Date: 01-Sep-2023
Our Ref: 2023/90937

**Application for a non-material amendment following a grant of planning permission,
Town and Country Planning Act 1990**

**Non material amendment to previous permission 2019/93755 for internal and
external alterations to convert dis-used warehouse to 8 apartments (Listed Building
within a Conservation Area)
22, Station Road, Batley, WF17 5SU
Application Number: 2023/90937**

DATE: Jan 2023 Dwg No: Rev.
 SCALE: 1:50 @A1 21057-8004

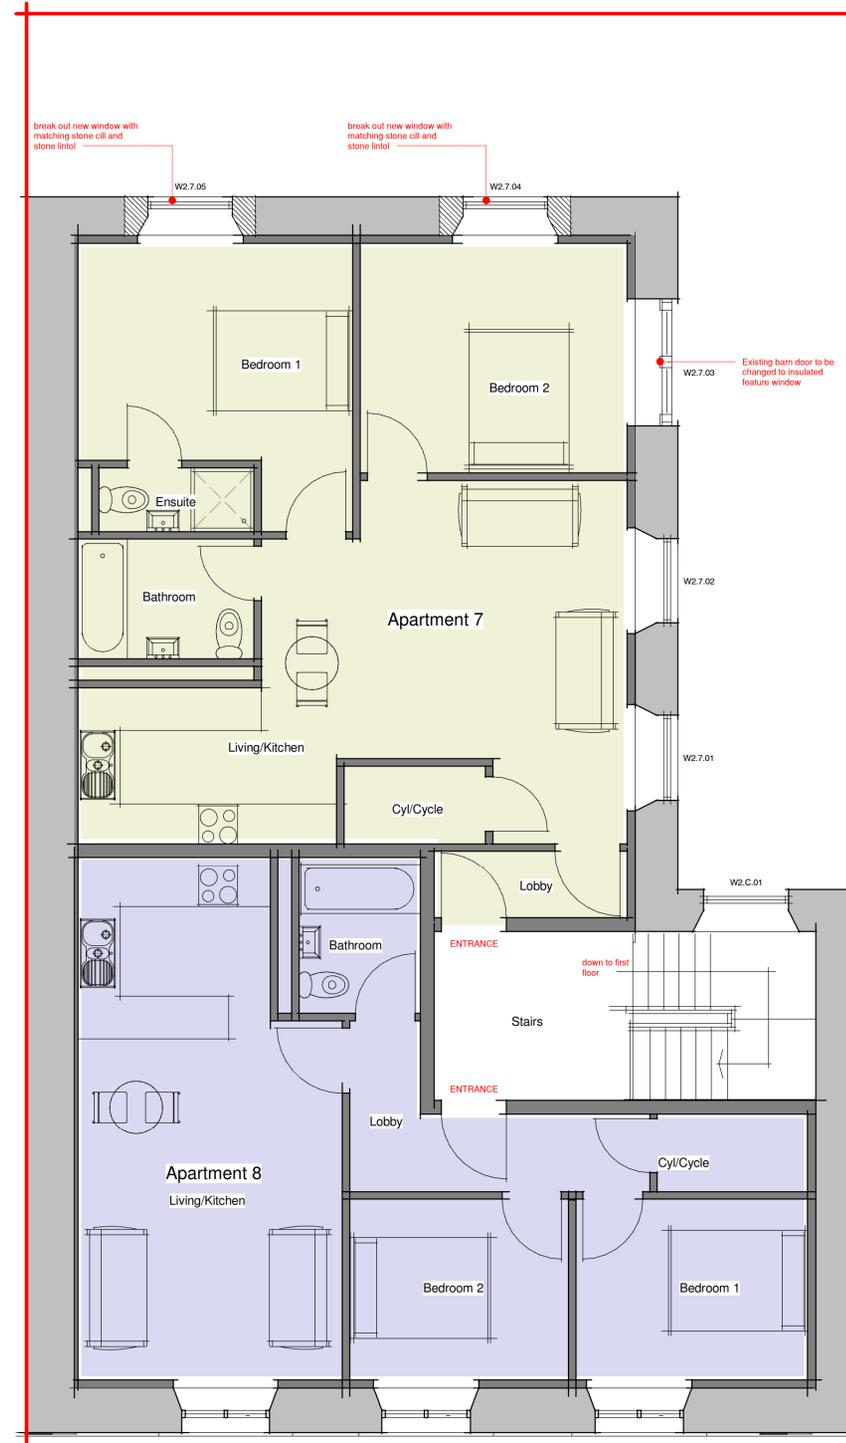
Thank you for your application dated 22-Aug-2023 for a non-material amendment to the above scheme. The amendment sought is to alter the stairs and access to the side, alter the partition wall on the ground floor and alterations to the windows on the front elevation at basement level as indicated on drawing No/s "Internal Finishes Basement/Ground – 21057-8006", "Proposed Basement/Ground Floor Plan – 21057-8003", "Proposed 1st & 2nd Floor Plan – 1057-8004" and "Proposed Elevations – 21057-8001".

I confirm that the alterations are acceptable and may be considered as a non-material amendment to the approved drawings. It should be noted that this letter relates only to the non-material amendment sought and it is not a re-issue of the original planning permission. The two documents should be read together and as such, all conditions imposed on the original granting of planning permission apply to the proposal as now amended. A copy of this letter and the amended plans will be retained on the public record of approved documents.
